March 14, 2014

Sheridan Street Townhouses
Addendum 1

The following specification sections shall be modified as follows

STAIRS
a3.5

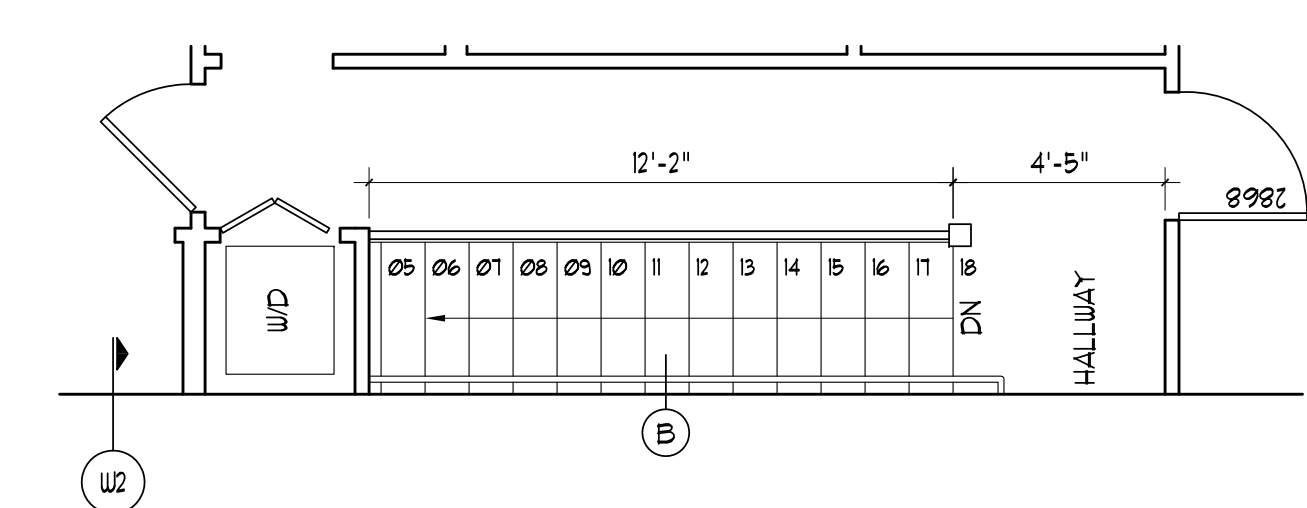
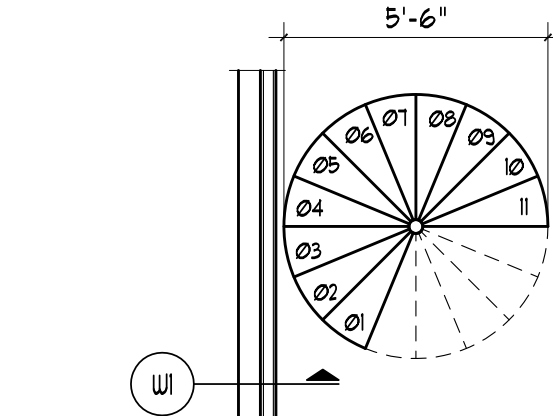
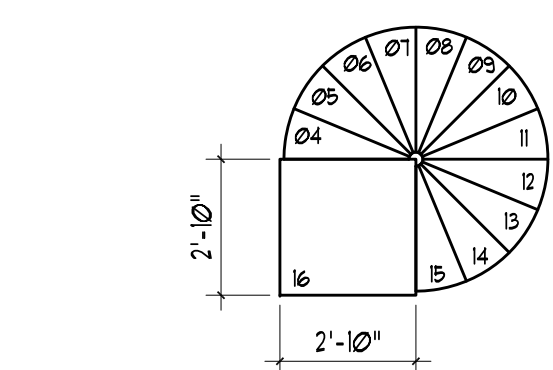
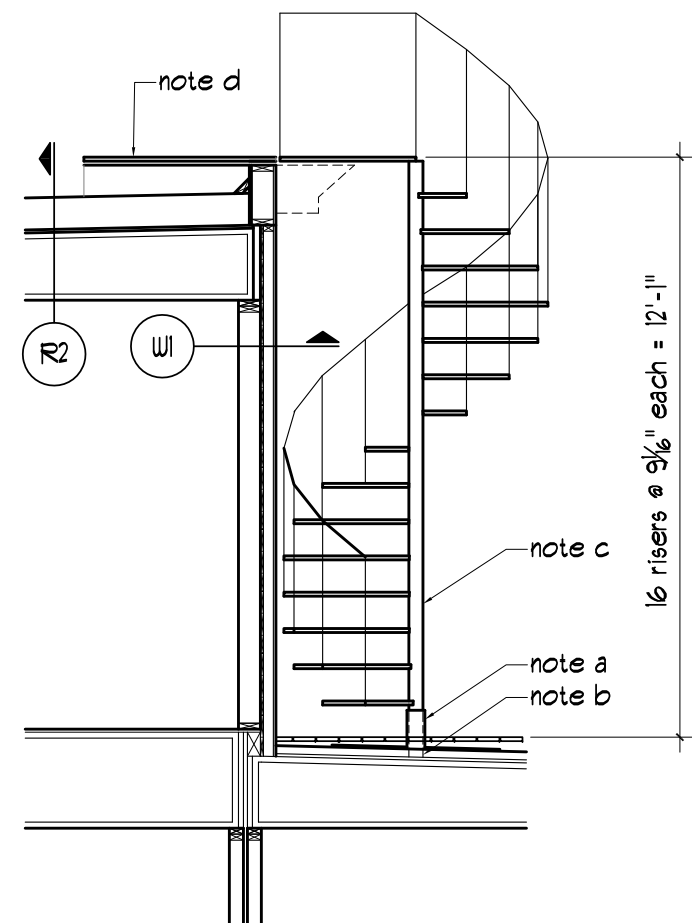
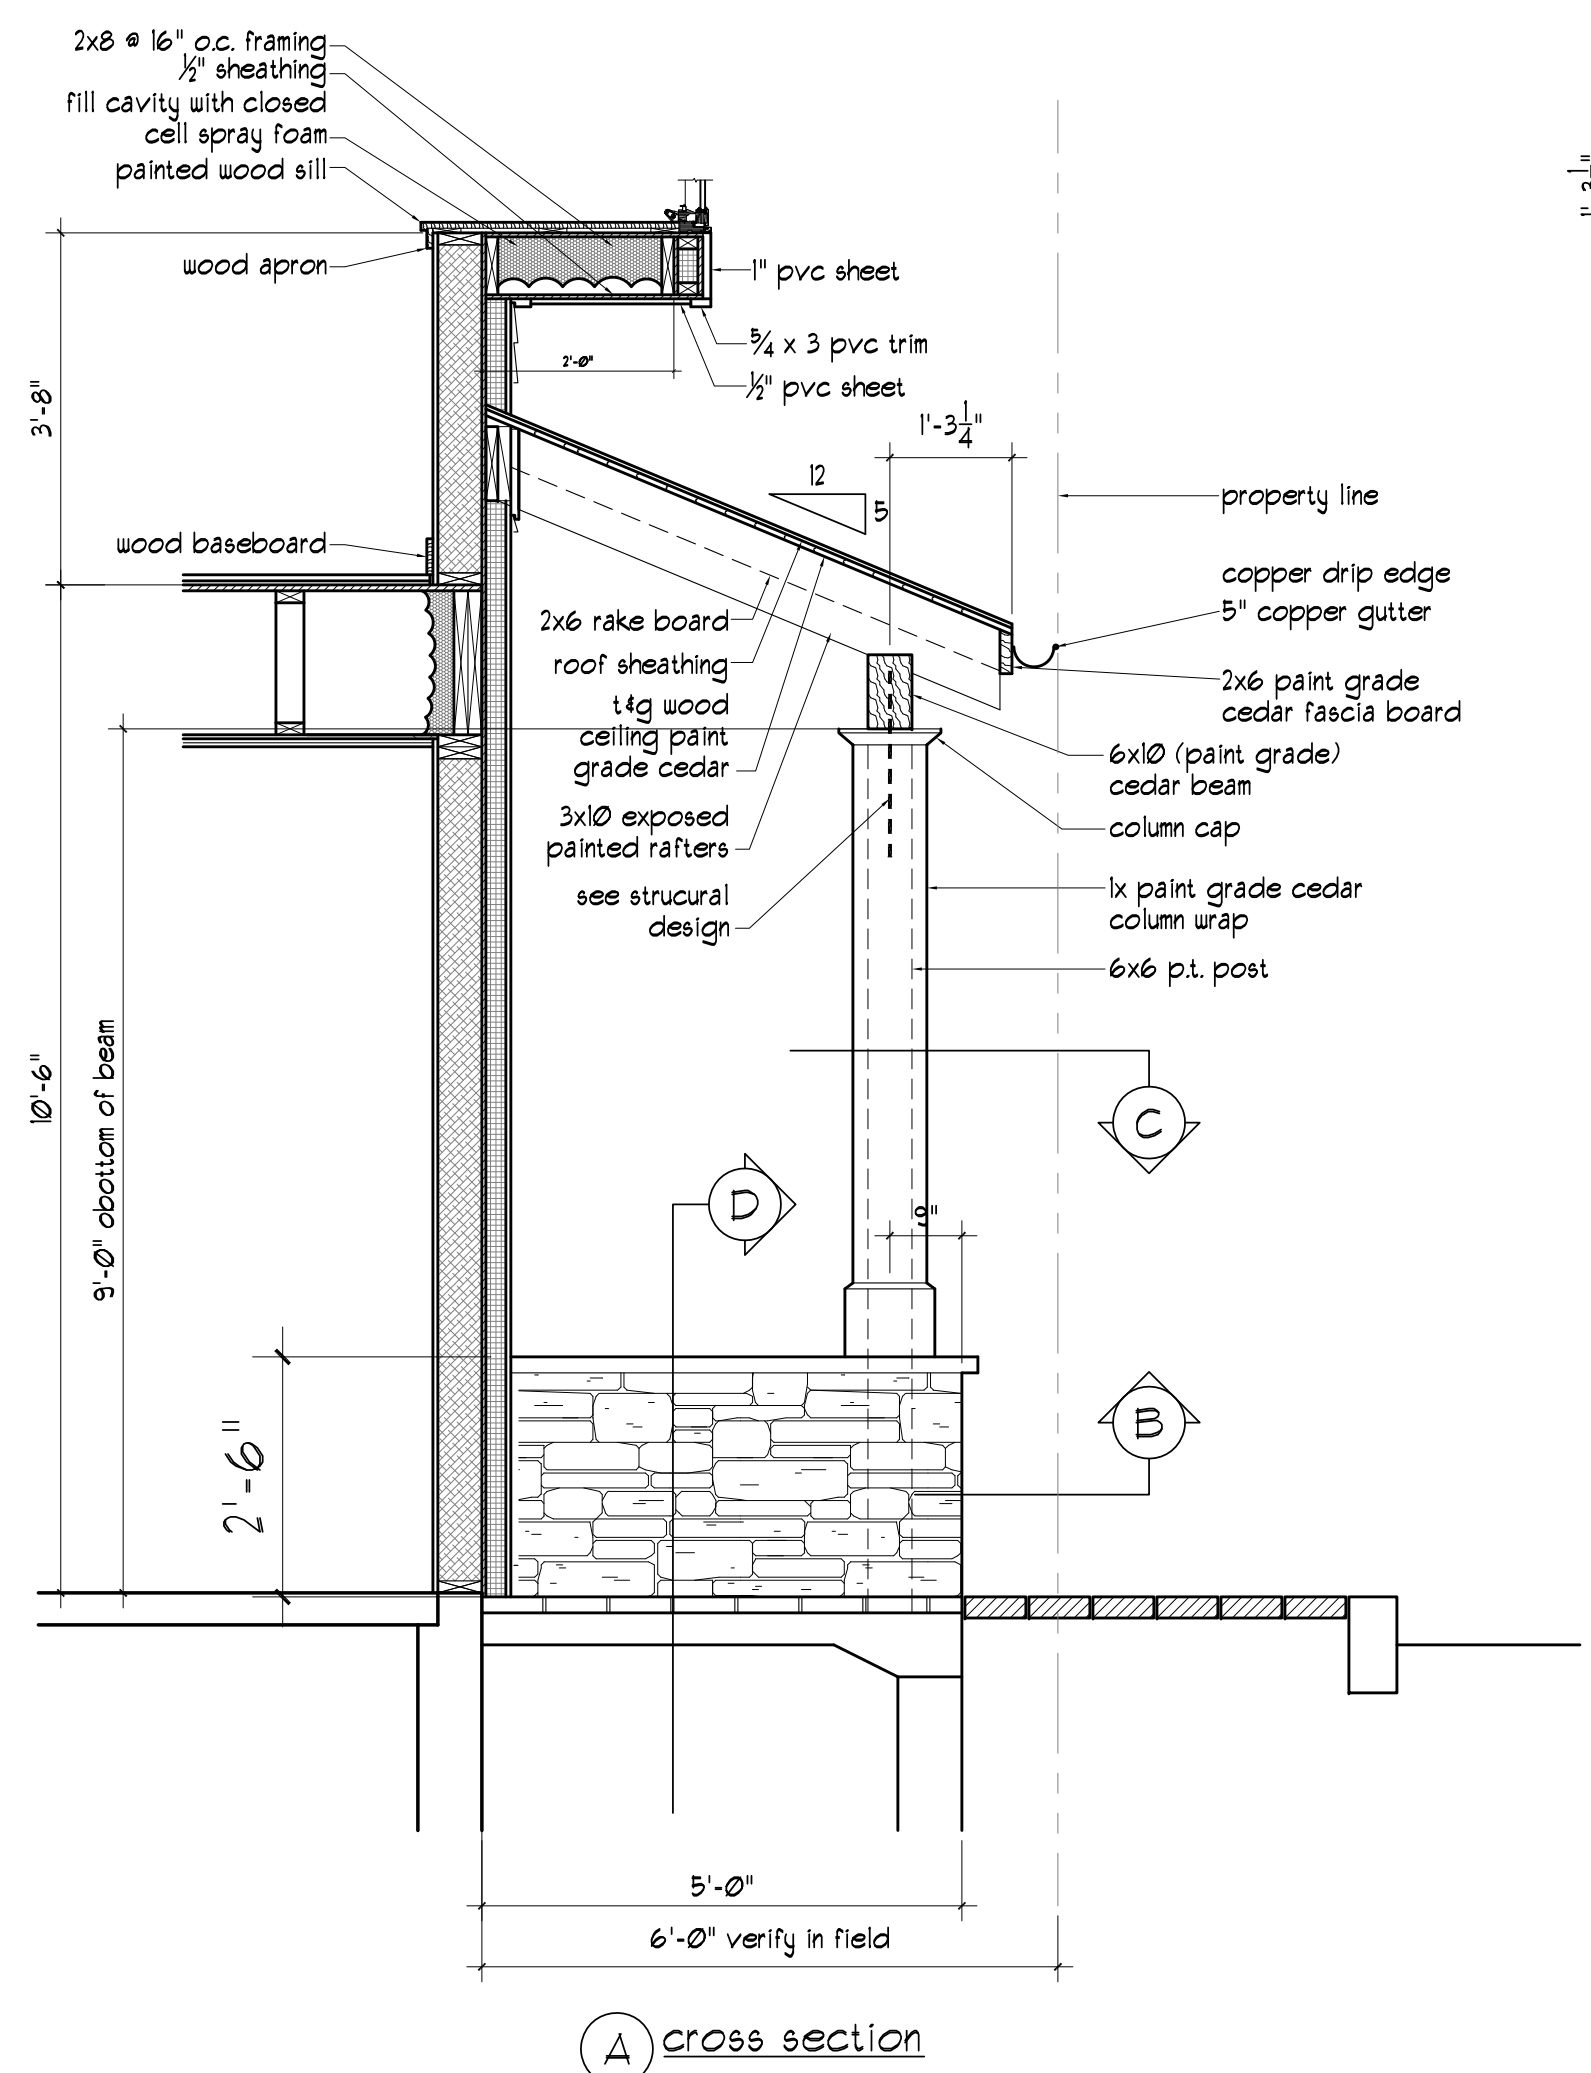
2.5 Skirt board at stair shall be 1x10 birch, not 6" as called for in specifications, and not paintable as shown on drawings.

Door Schedule

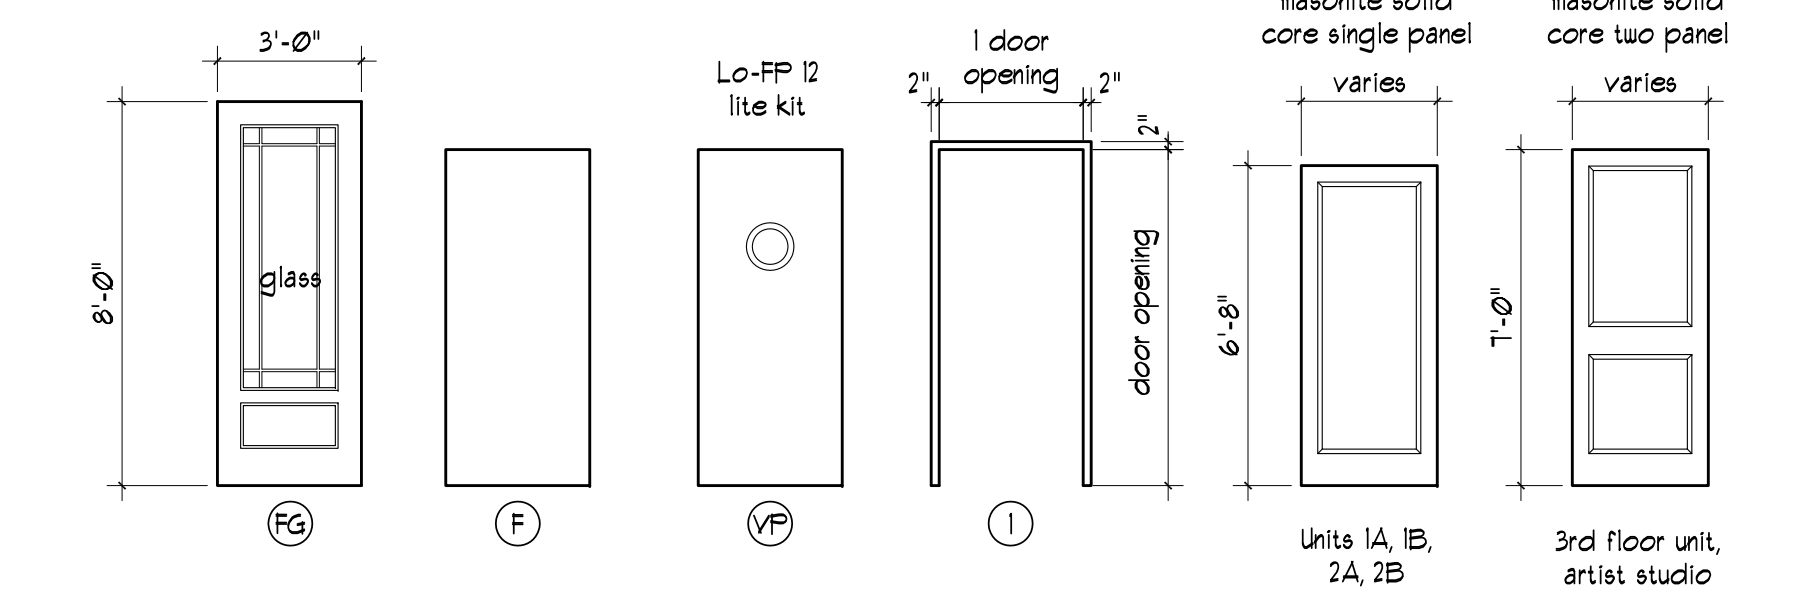
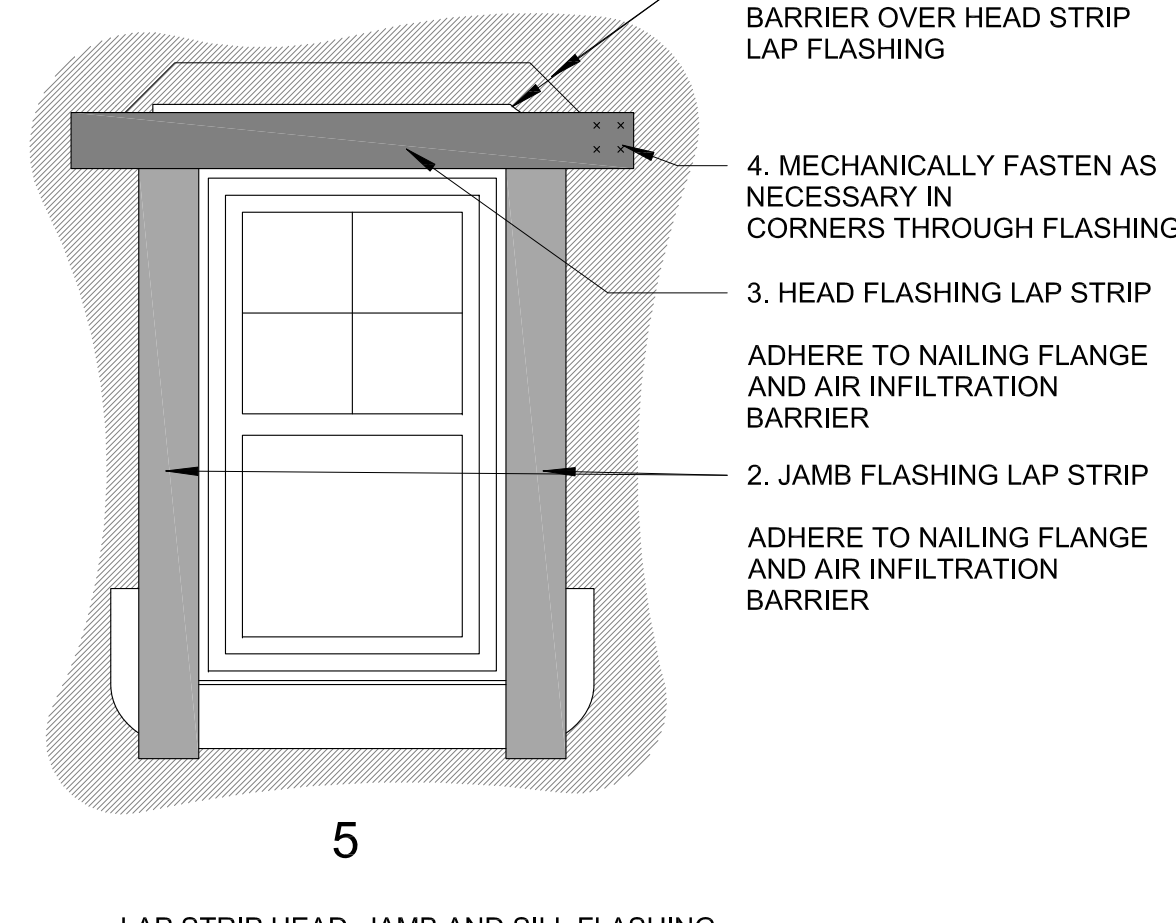
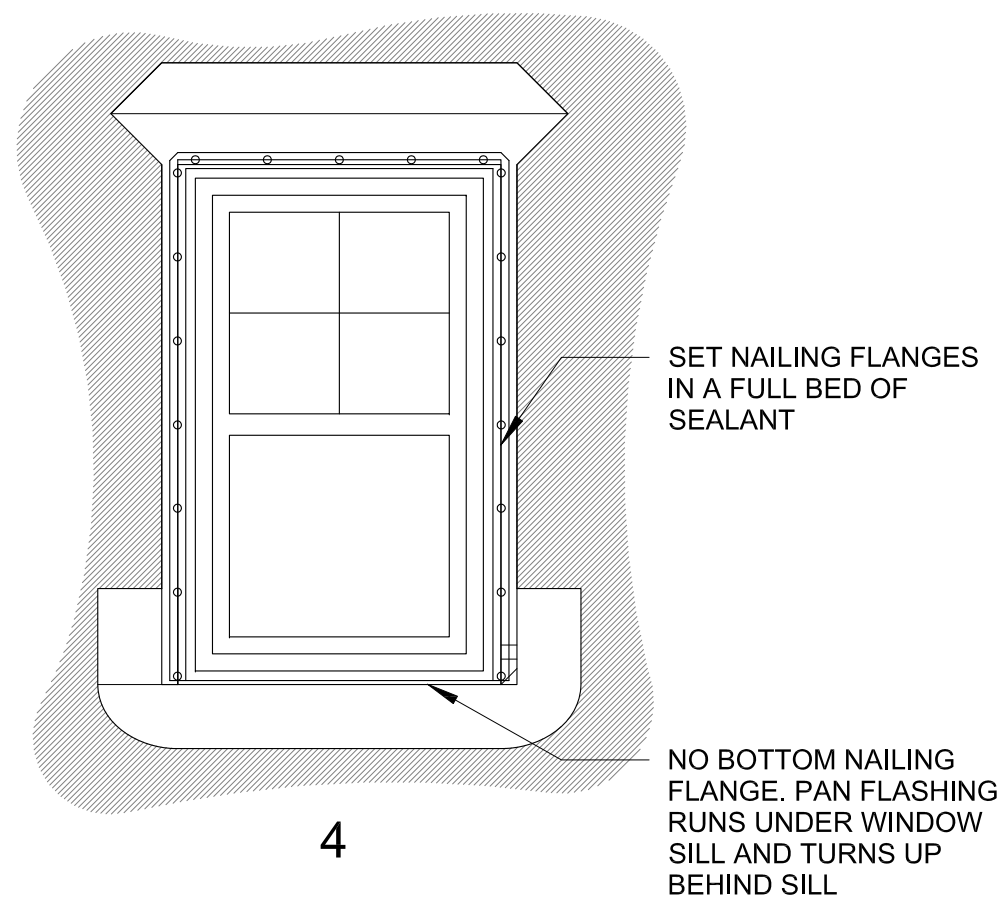
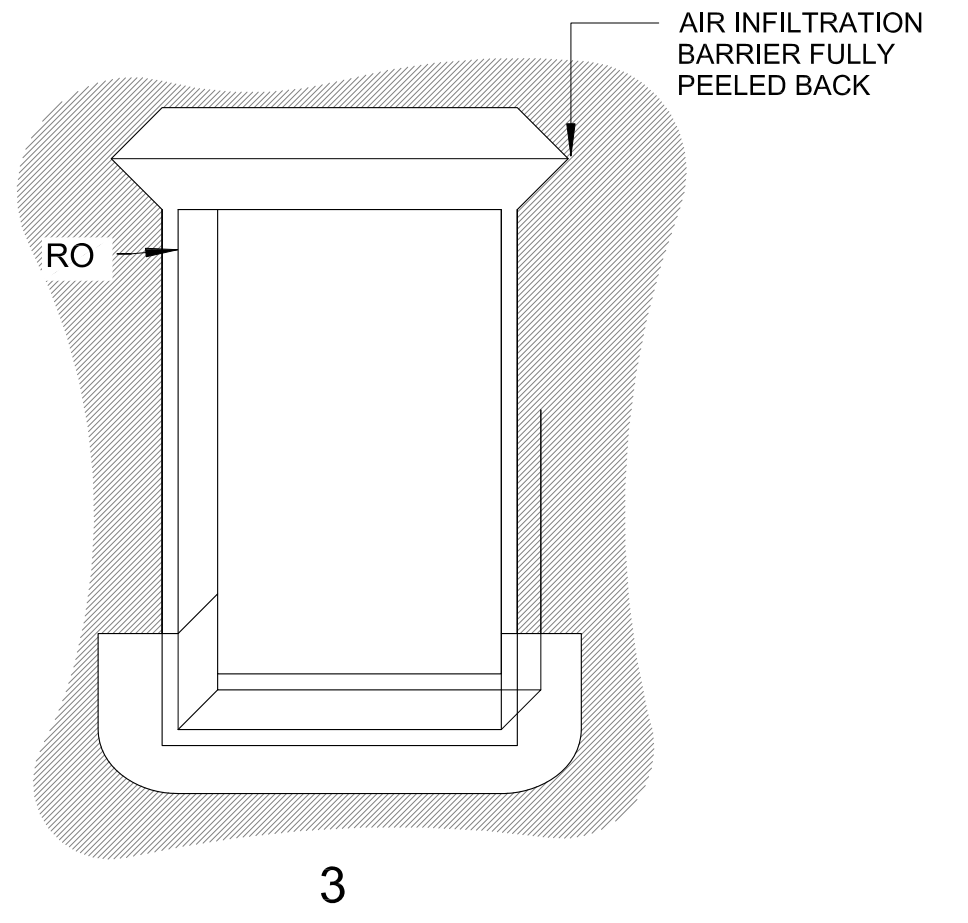
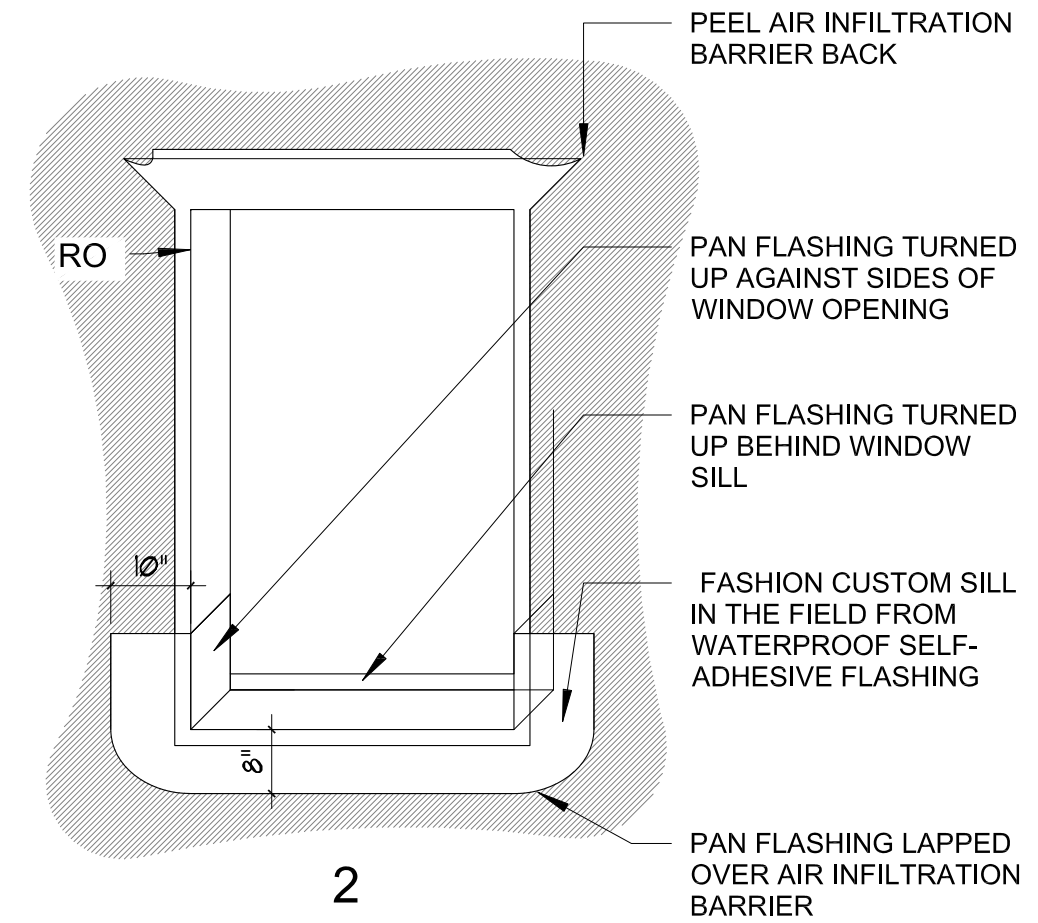
08000-Doors: Note that only Apartment doors that lead to a corridor are 20 minute rated. The doors to apartments 2A and 3A open into the rated shaft and shall be 1 hour rated doors and frames, as shown on the door schedule
